Your Ref: Norwich-Tilbury Drainage Strategy Ref: FW2026_0440
Date: 09 June 2026 Tel No.: 0344 800 8020
Email: llfa@norfolk.gov.uk

Norwich to Tilbury: LLFA Review of Drainage Strategy

Thank you for your consultation on the above site, received on 28 May 2026. The LLFA have reviewed the submitted information and have the following comments to make.

Revision:  
**B**

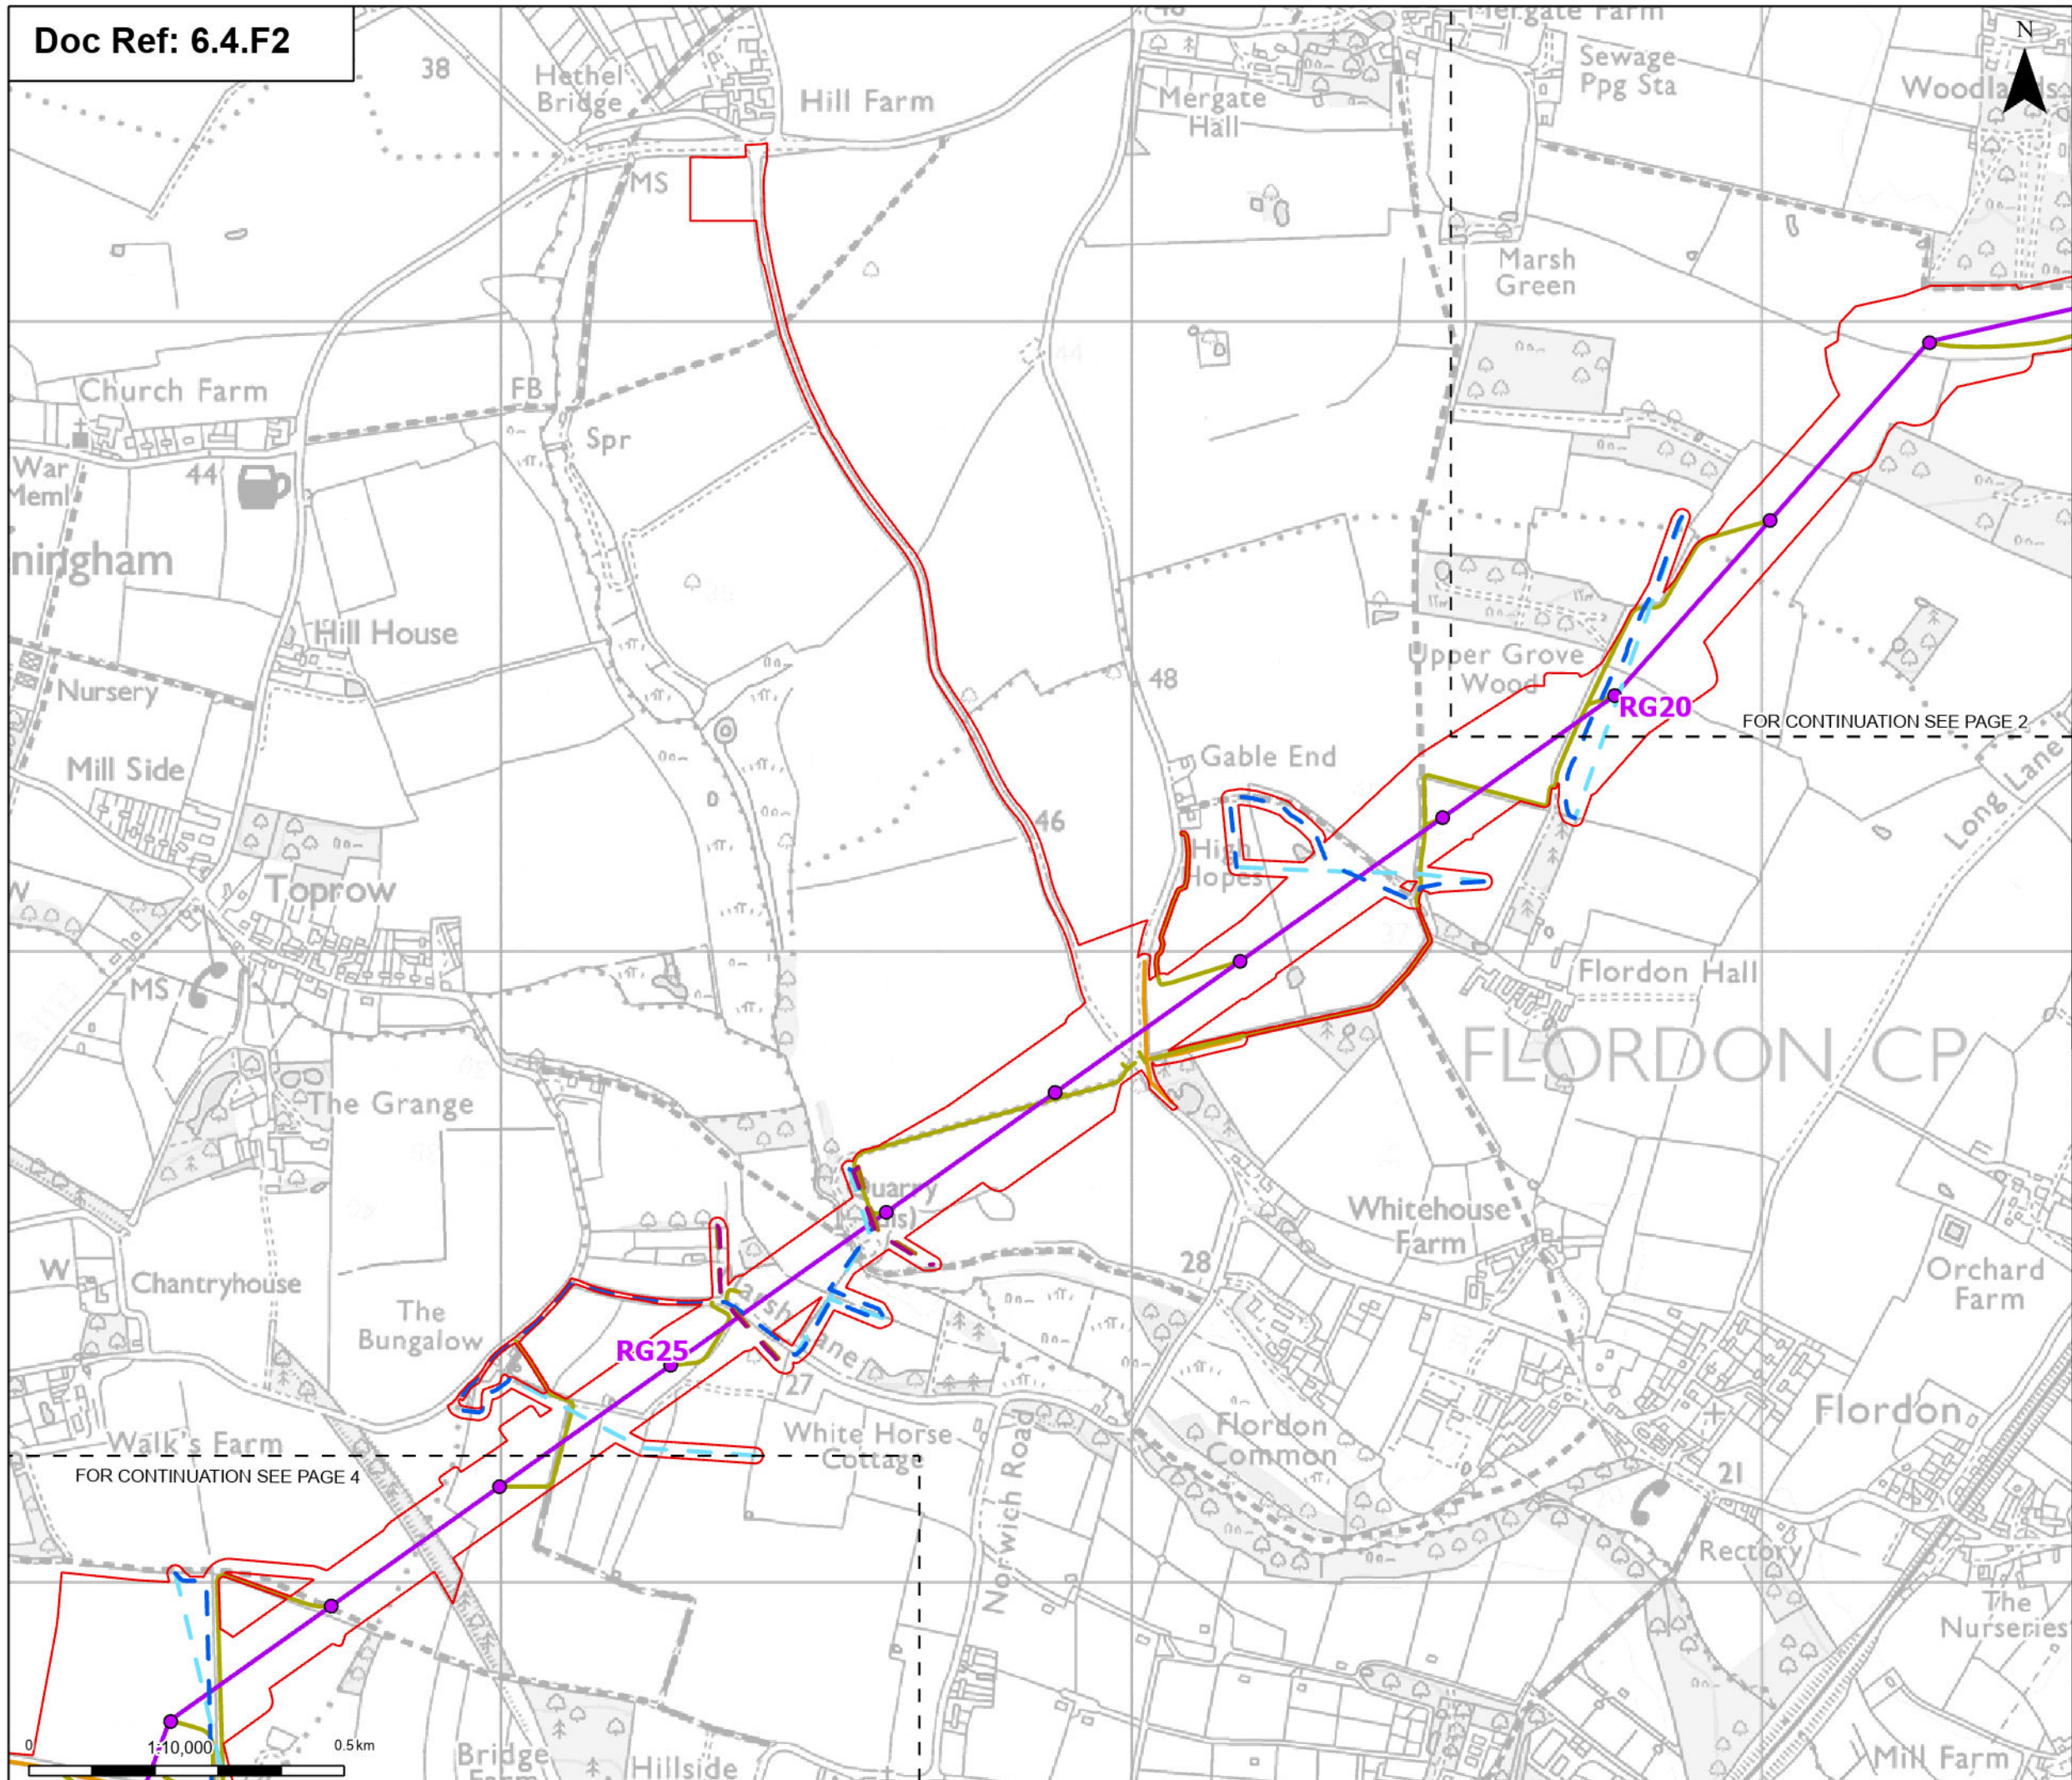
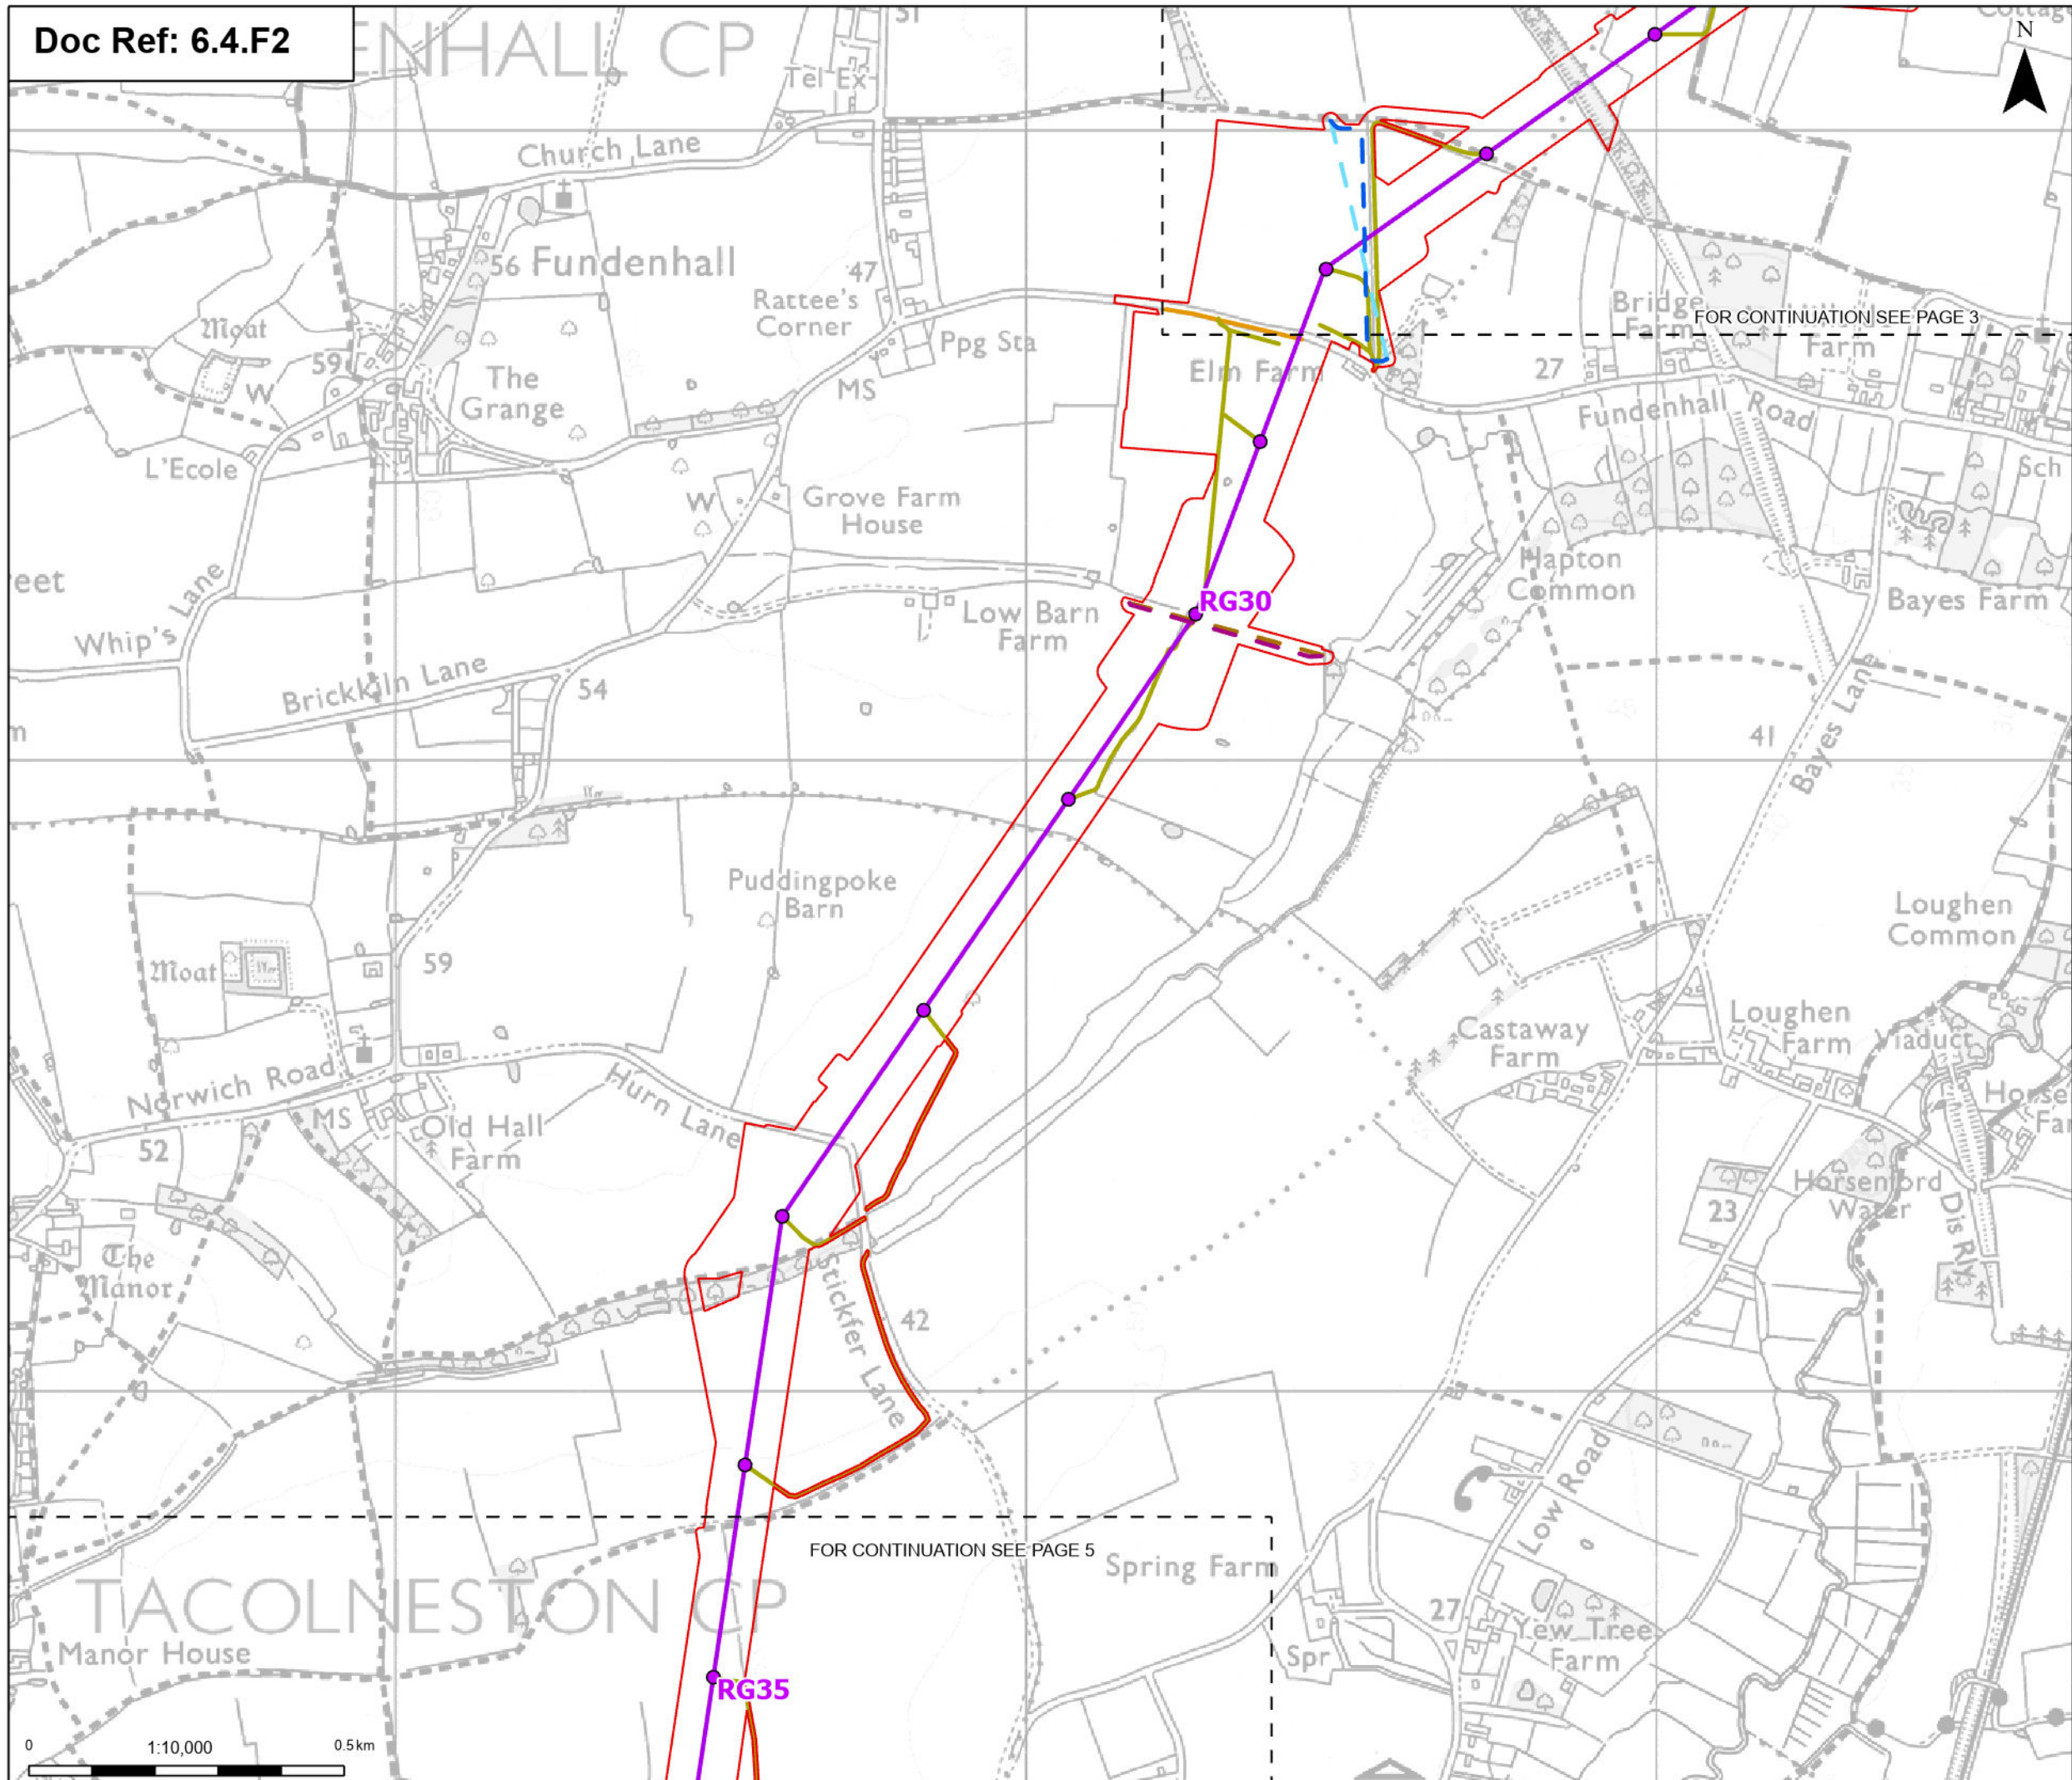
On review of Figure 4.1, Figure 4.2 and Appendix A, it is not possible to make a connection between the information and references provided in the drawings and the information provided in Appendix A. In Figure 4.1, the proposed overhead line construction SuDS basins are the only SuDS features with a symbol on the plans. These SuDS features are not labelled in Figure 4.1. In Appendix A, a pond reference number is provided along with a contributing catchment area. This information is not provided in either Figures 4.1 or 4.2. Furthermore, the order of the ponds appears to not be provided in a north to south approach and is therefore inconsistent with the approach taken in the previous section of the drainage strategy. In Appendix A, there are a number of statements in the "notes/assumptions/risks" section that state "Infiltration of surface water considered unsuitable. Shallow groundwater not identified." followed by a statement of "Infiltration may be deemed possible after infiltration test." This indicates to the LLFA that at present no ground investigation has taken place. Therefore, it is not possible for the applicant to determine whether infiltration is viable. The LLFA Developer Guidance is clear that where in the early stages of design that infiltration testing has not been undertaken, the developer should assume that infiltration is possible as a Plan A approach while demonstrating that a viable Plan B is available. At present, the applicant has not been able to demonstrate that either a Plan A or a Plan B could be viable due to a lack of information. It is also not possible to check or

confirm the whether the proposed discreet drainage catchment area is appropriate and therefore, that the appropriate sizing of the attenuation basin has occurred. Further work and information is required.

LLFA June 2026 Response - Not Resolved - No changes have been made to Appendix A. It continues to not be possible to make a connection between the information and references provided in the drawings and the information provided in Appendix A. Further work and information is required.
